SUBJECT: Engineering Review Comment  
Mountain View Electric Association Inc. (MVEA)

**Project Name: Settlers Ranch Filing 3 – Final Plat**

**Project Number: SF249**

**Description:** A proposed development of 24 lots and 1 tract located east of Settlers Ranch Rd and north of Hodgen Rd. in Township 11S, Range 66W, Sections 23 and 24.

SETTLERS RANCH SUBDIVISION FILING NO. 3

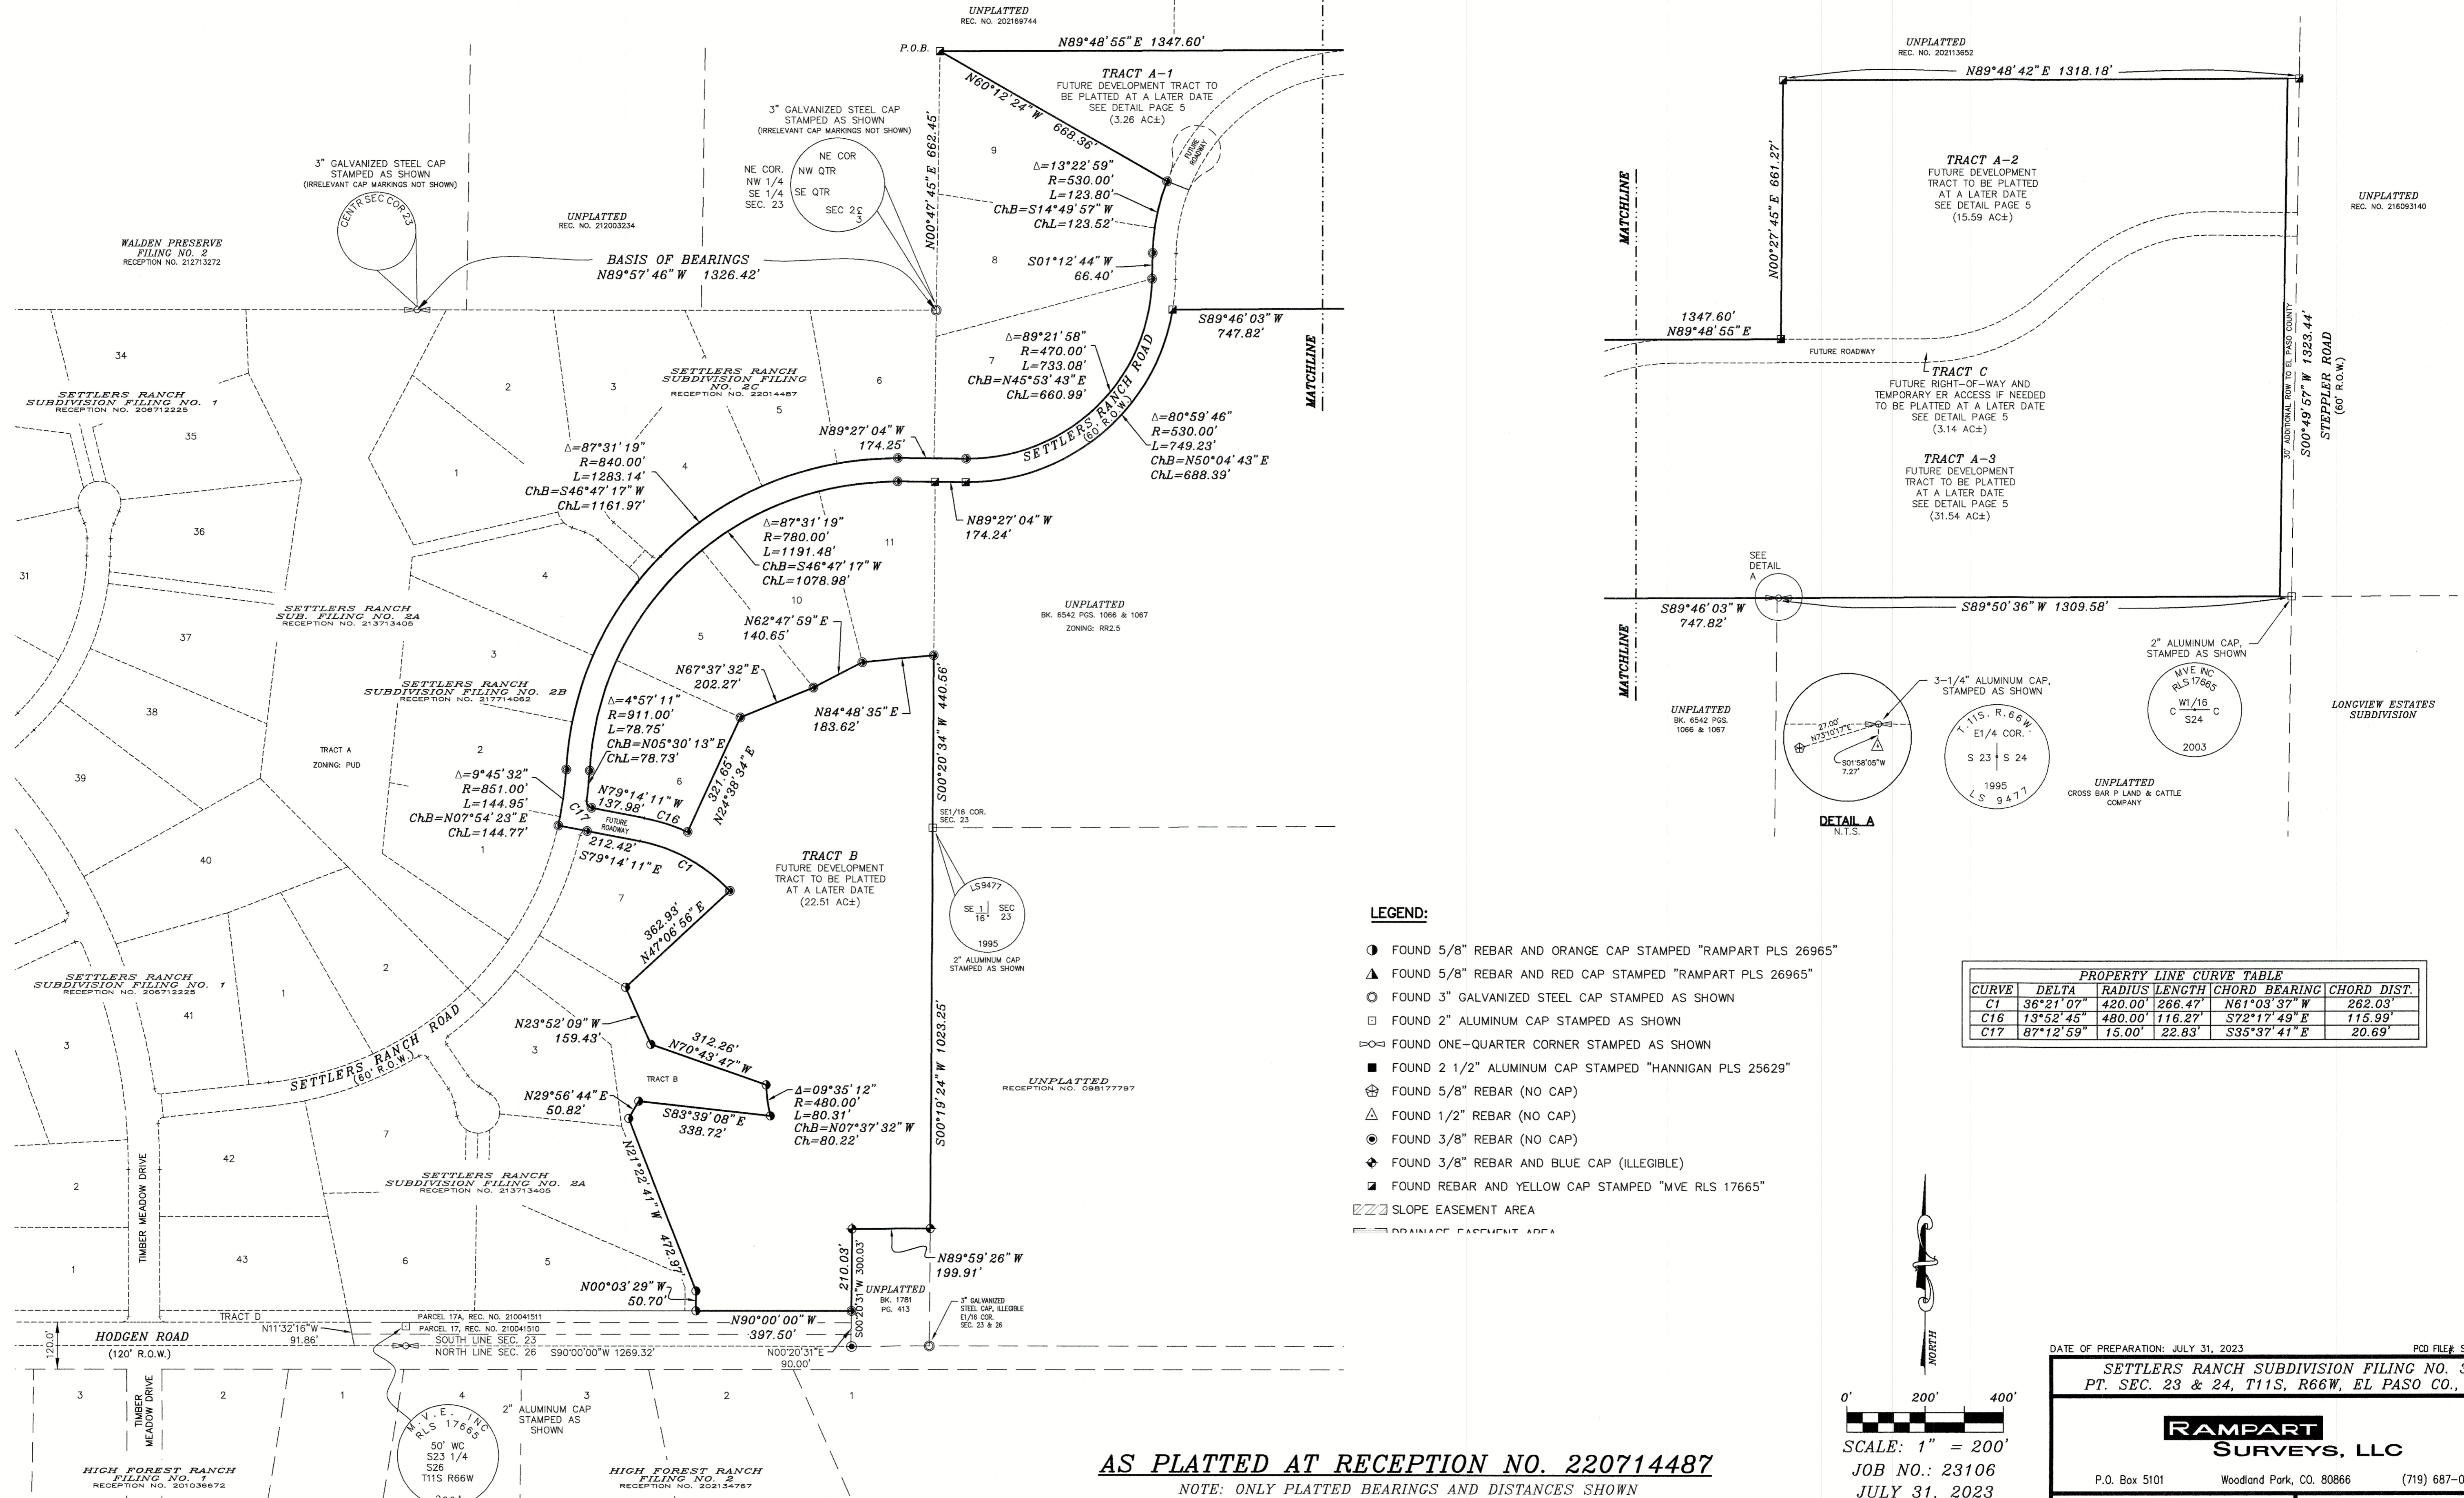
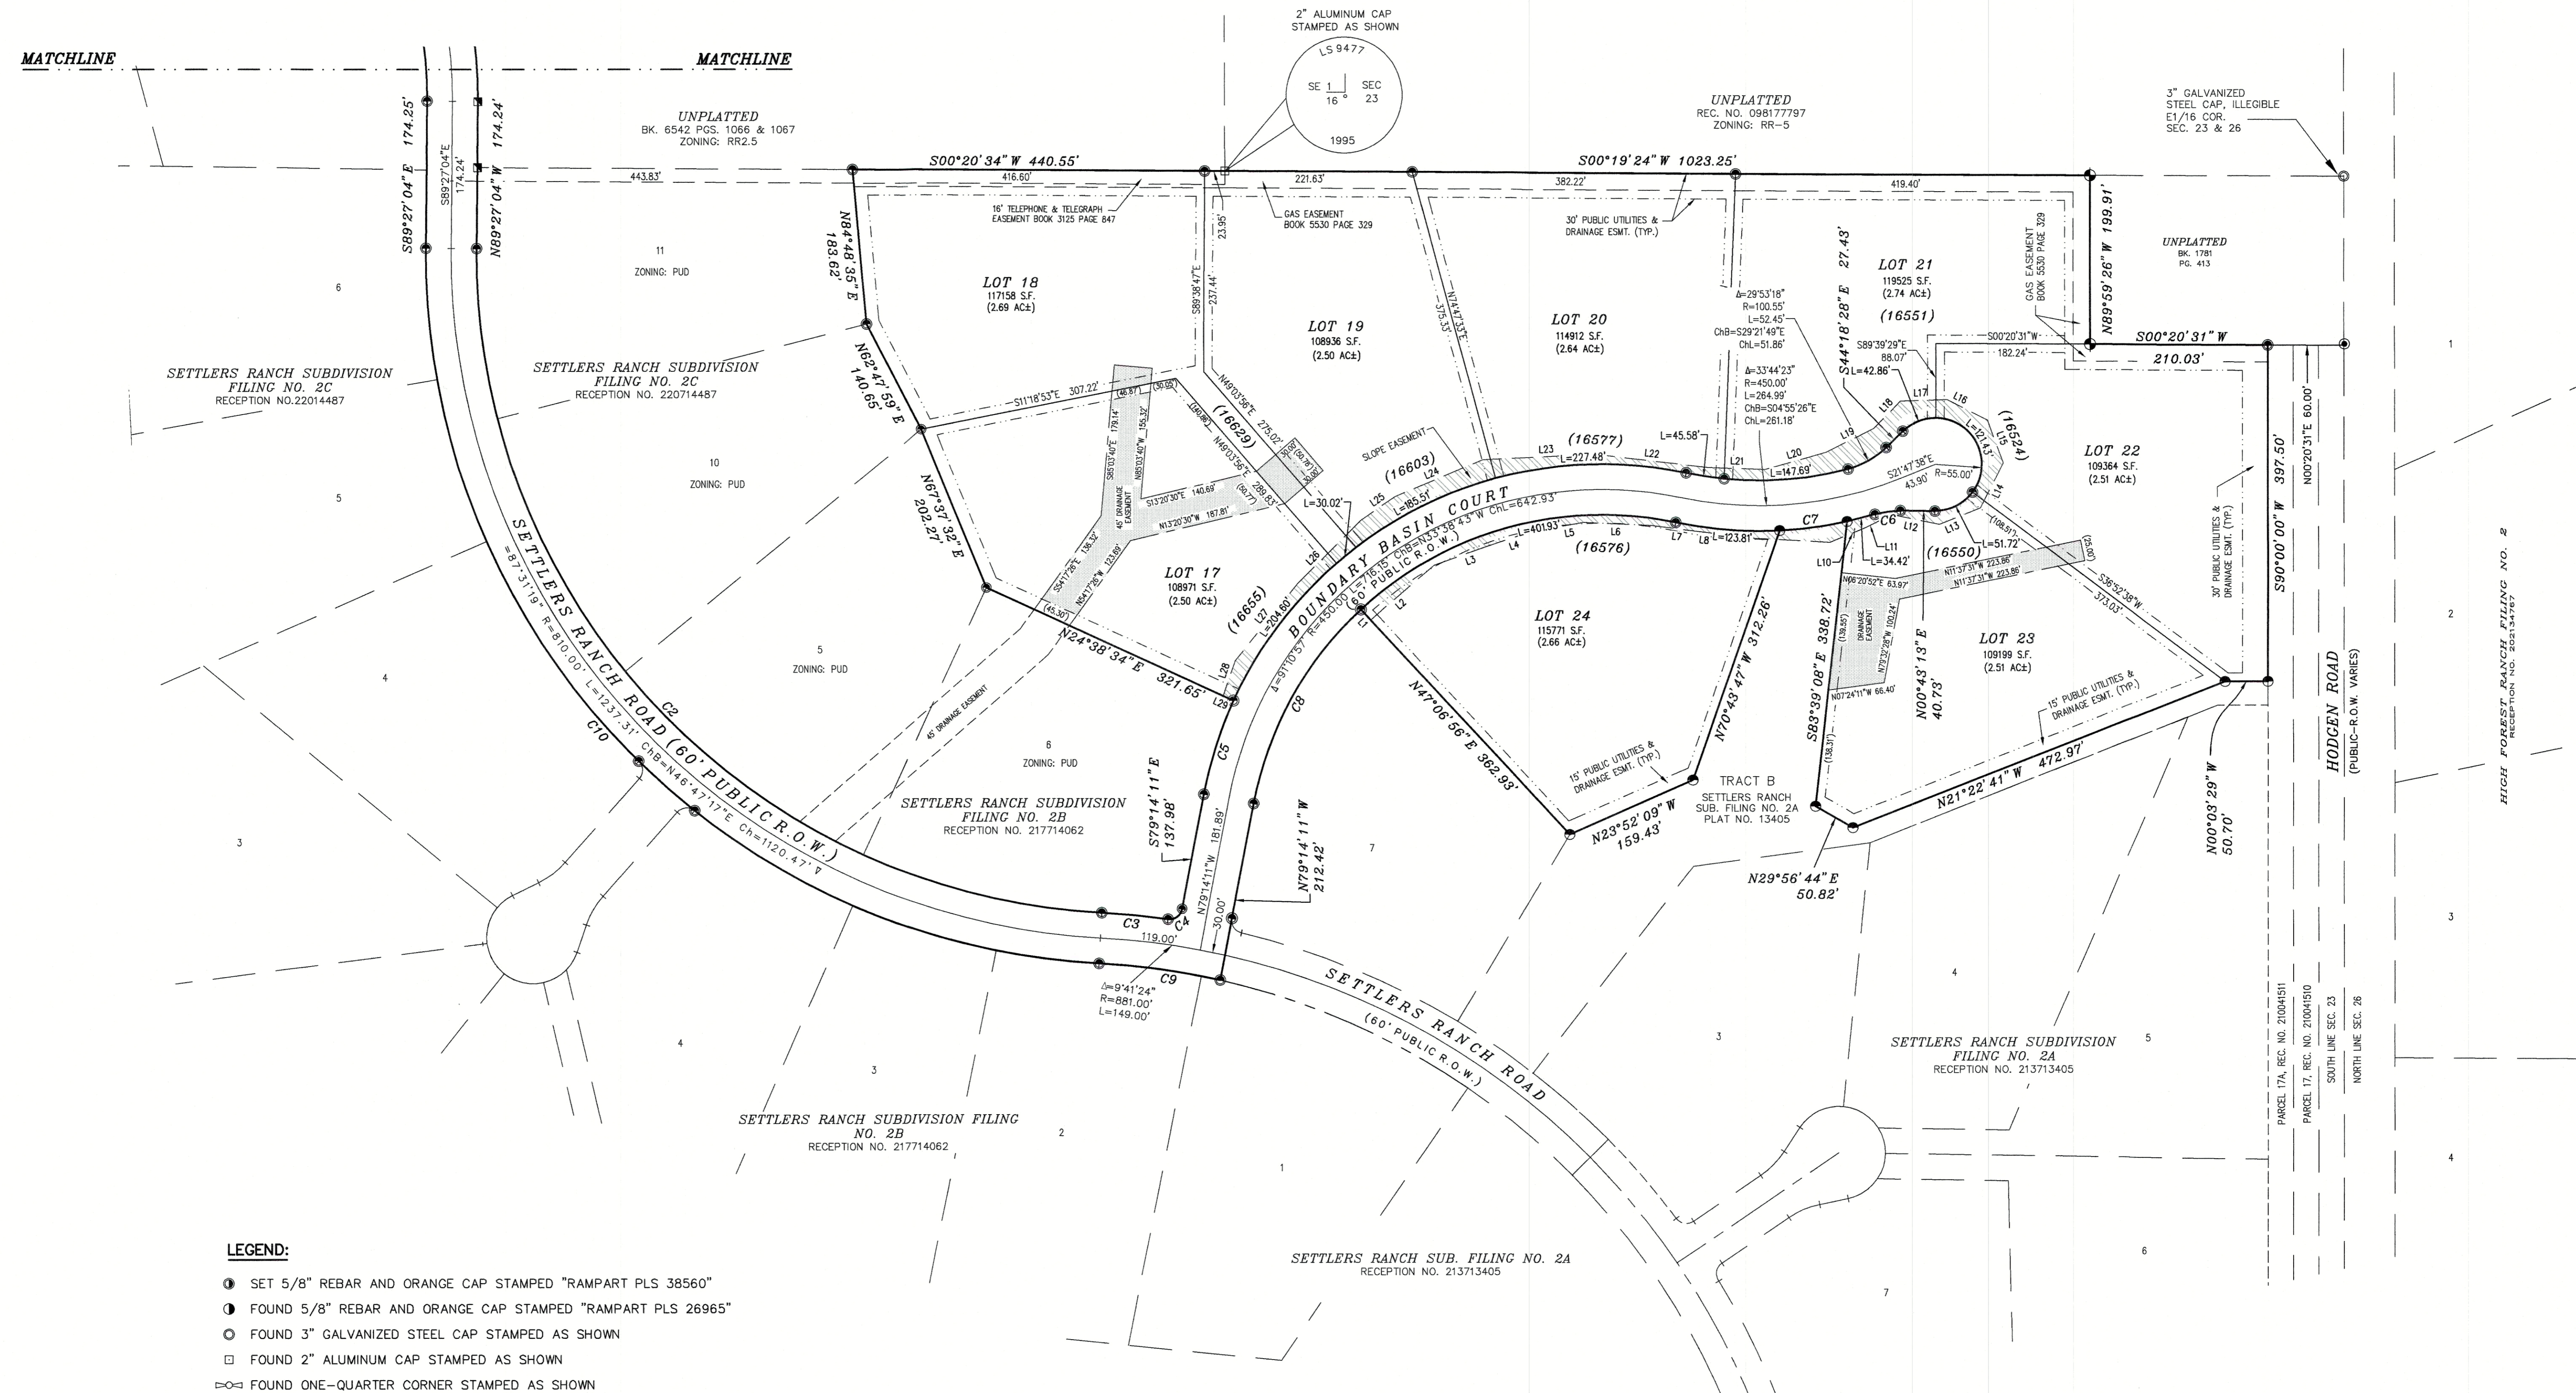
MVEA requests a ten (10) foot front, side, and rear lot utility easement and all tracts, along with a twenty (20) foot exterior utility easement on the plat. MVEA also requests the platting of MVEA's existing facilities with easements on the plat. Additional easements may be required.
